Your ref:	HSBC Covent Garden	<b>Please reply to:</b>	Rayhan Ali
Our ref:	24/00828/ADV	Tel No:	07866033247
		Fee Queries:	0207 641 6500;
		Email:	planningreception@westminster.gov.uk;
A&Q Partnership (London) Ltd A&Q Partnership (London) Ltd The Lux Building 2-4 Hoxton Square LONDON N1 6NU		<b>Incomplete Applications</b> Town Planning & Building Control City of Westminster PO Box 732 Redhill, RH1 9FL	
		14 February 2024

**Address: 16 King Street, Covent Garden, London, WC2E 8JF,**

**Proposal: Display of internally illuminated fascia logo measuring 0.72mm x 0.42mm  
(Linked with 24/00829/LBC)**

03 Proposed Detailed Section Of Affected Area
1:25@A3

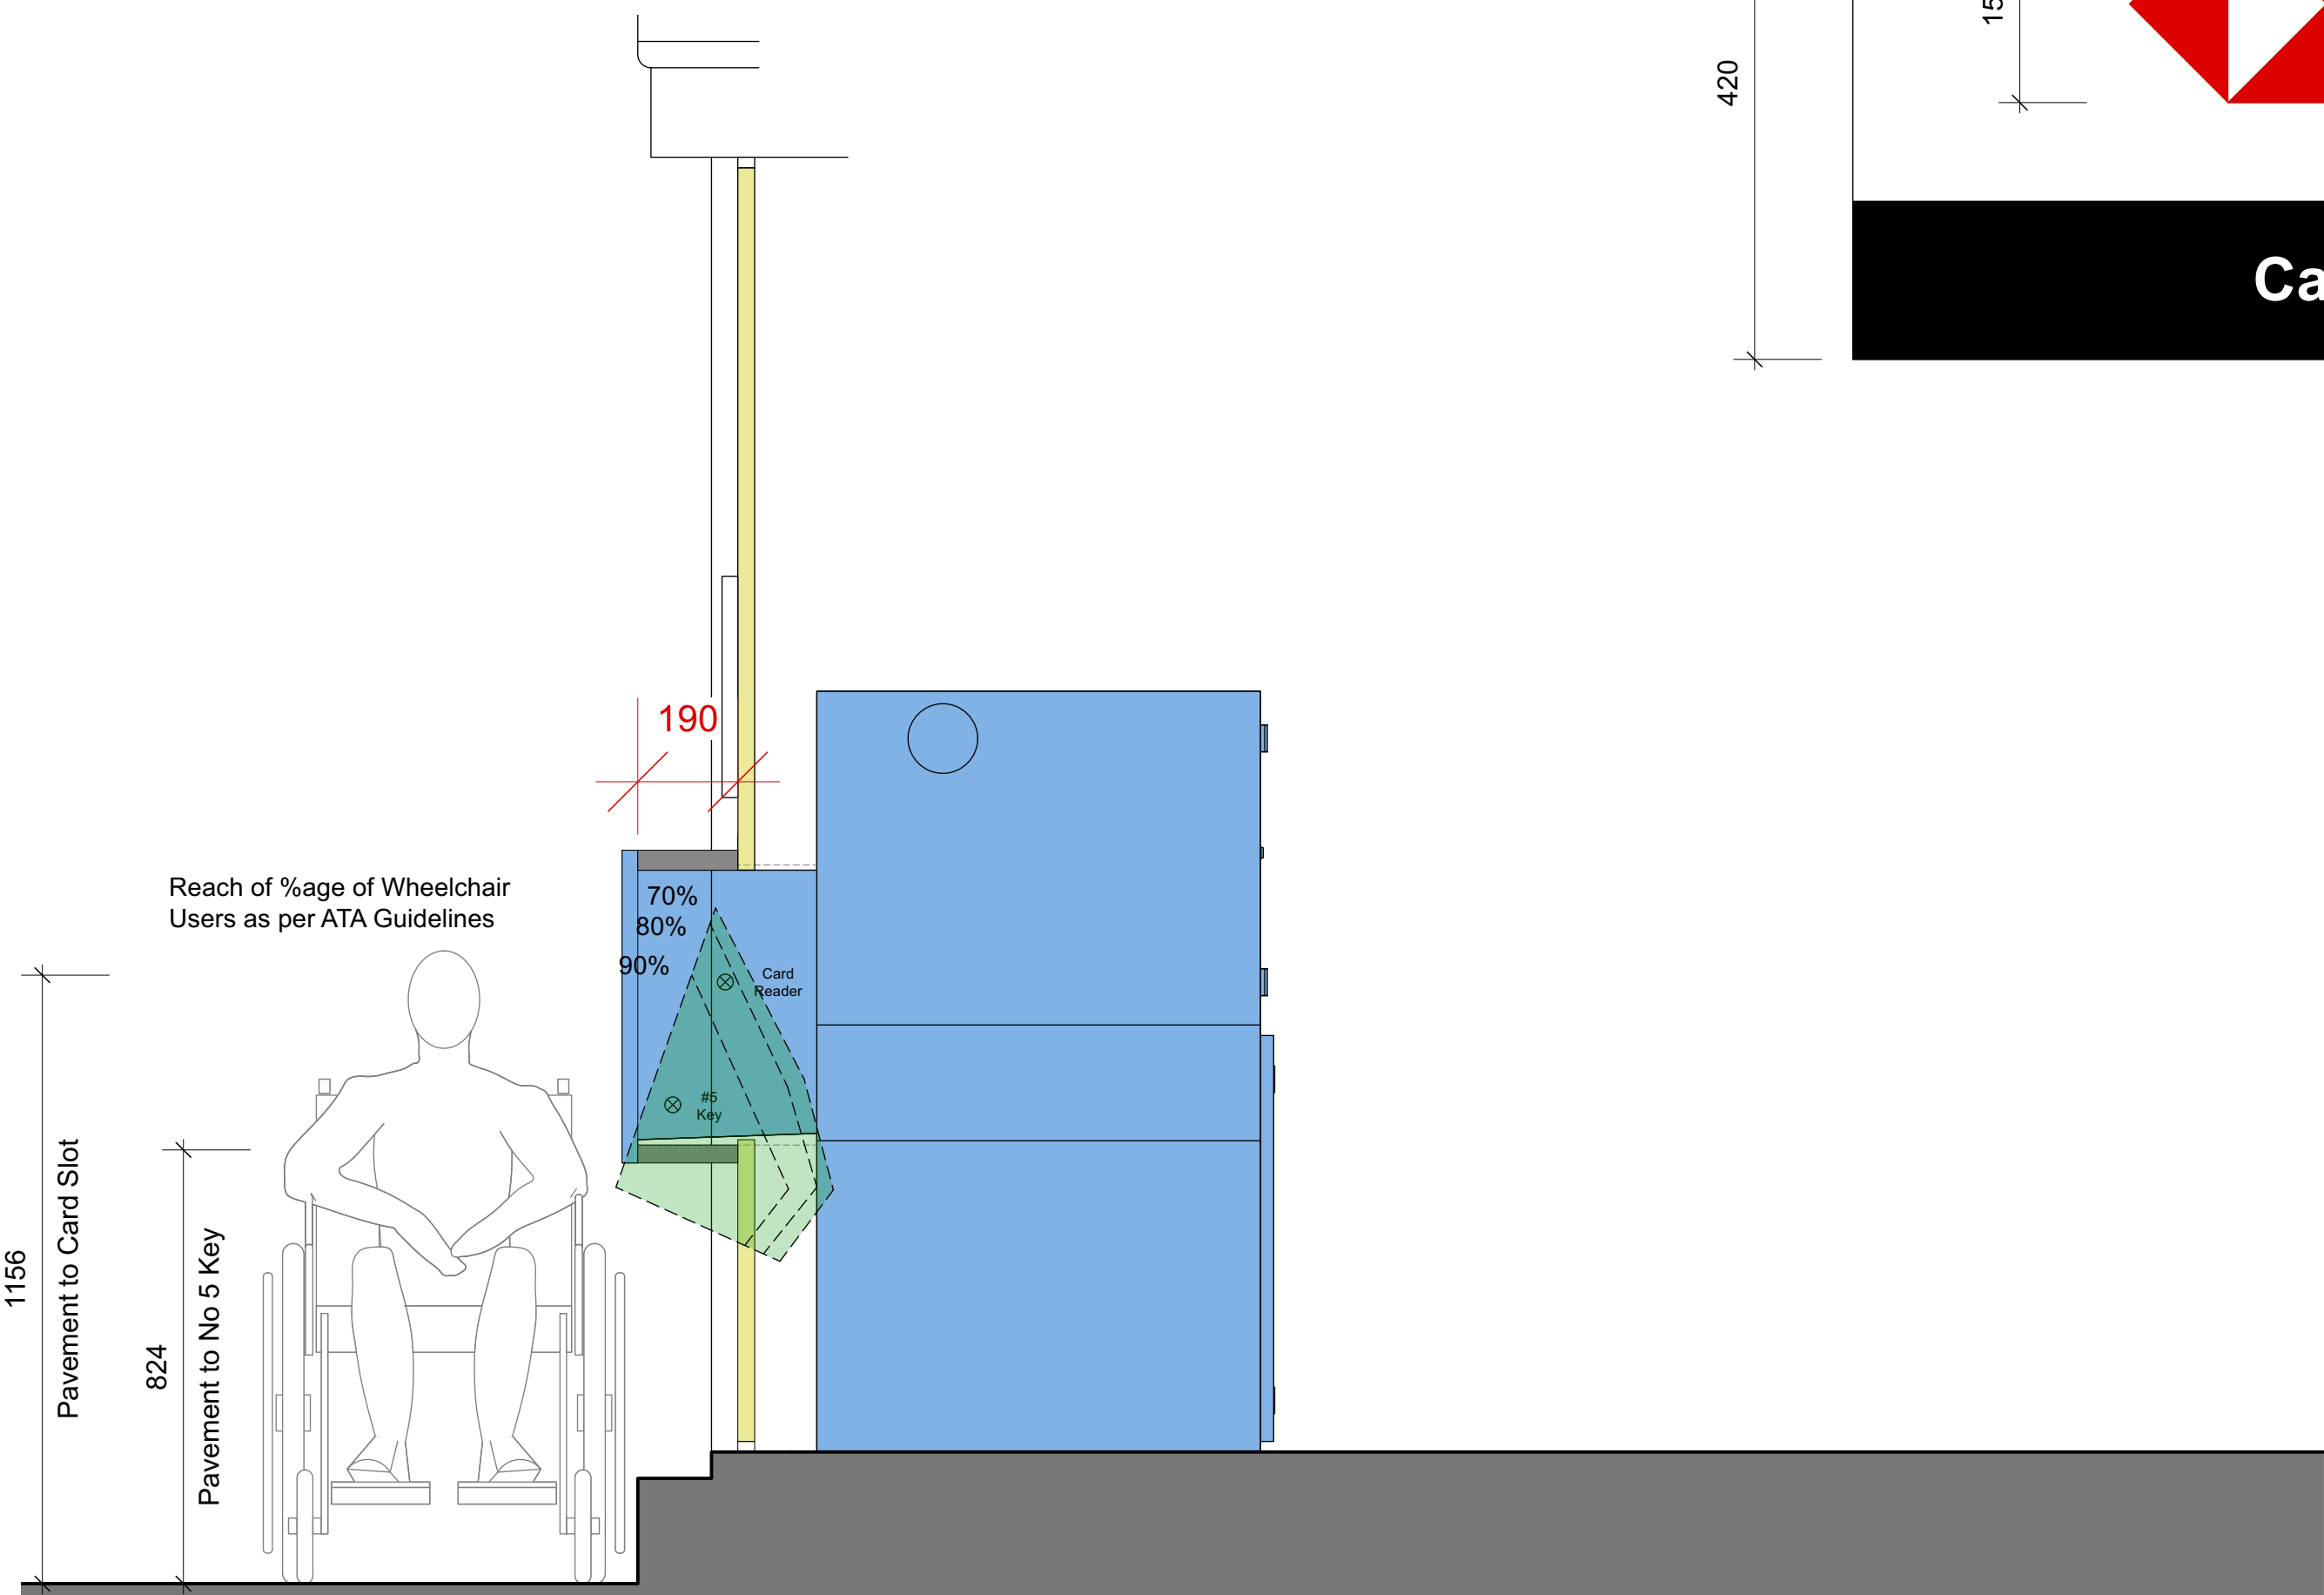
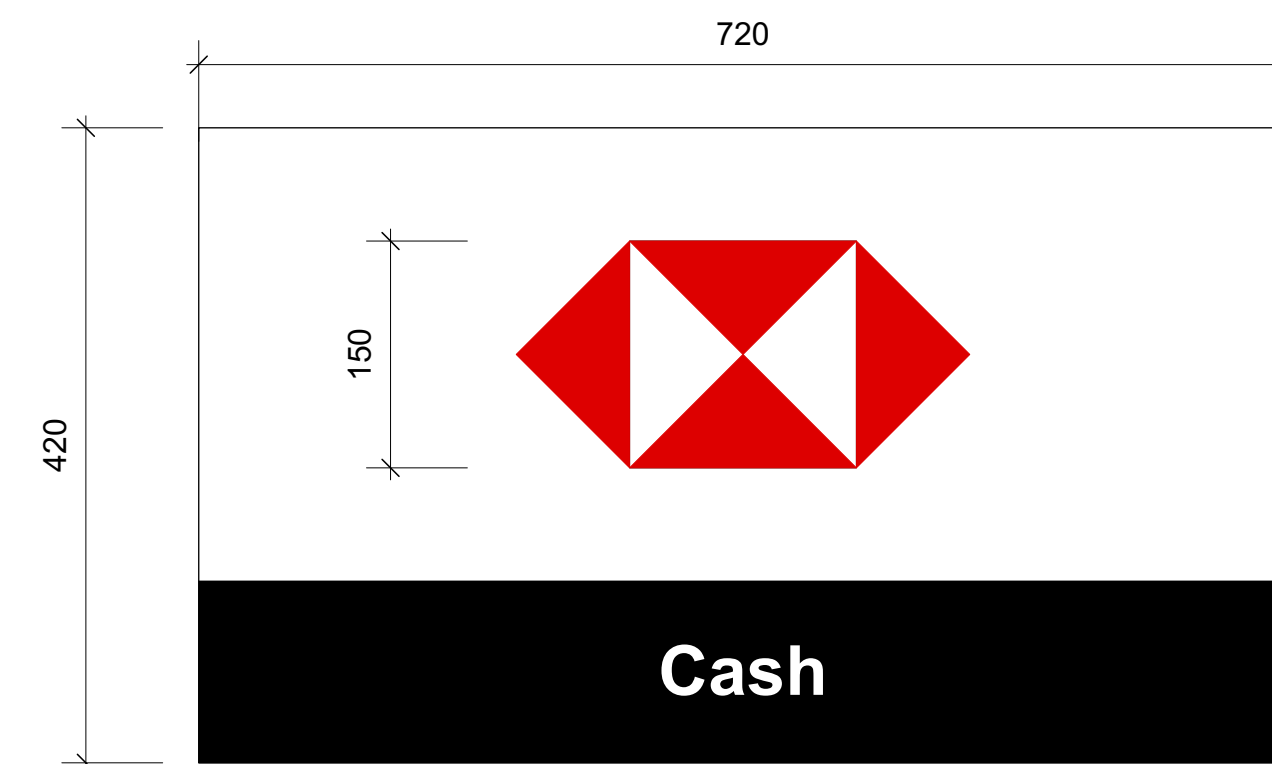
- 1 Please provide sections through the advertisements to show the method of illumination also confirm if this will be internally or externally illuminated.
- 2 \*Please collate all requested information in a single submission and send to [planningreception@westminster.gov.uk](mailto:planningreception@westminster.gov.uk). Sending your documents individually will not speed up the process. Please do not upload to the planning portal as this causes duplication and may delay the processing of your application. Thank you.\*
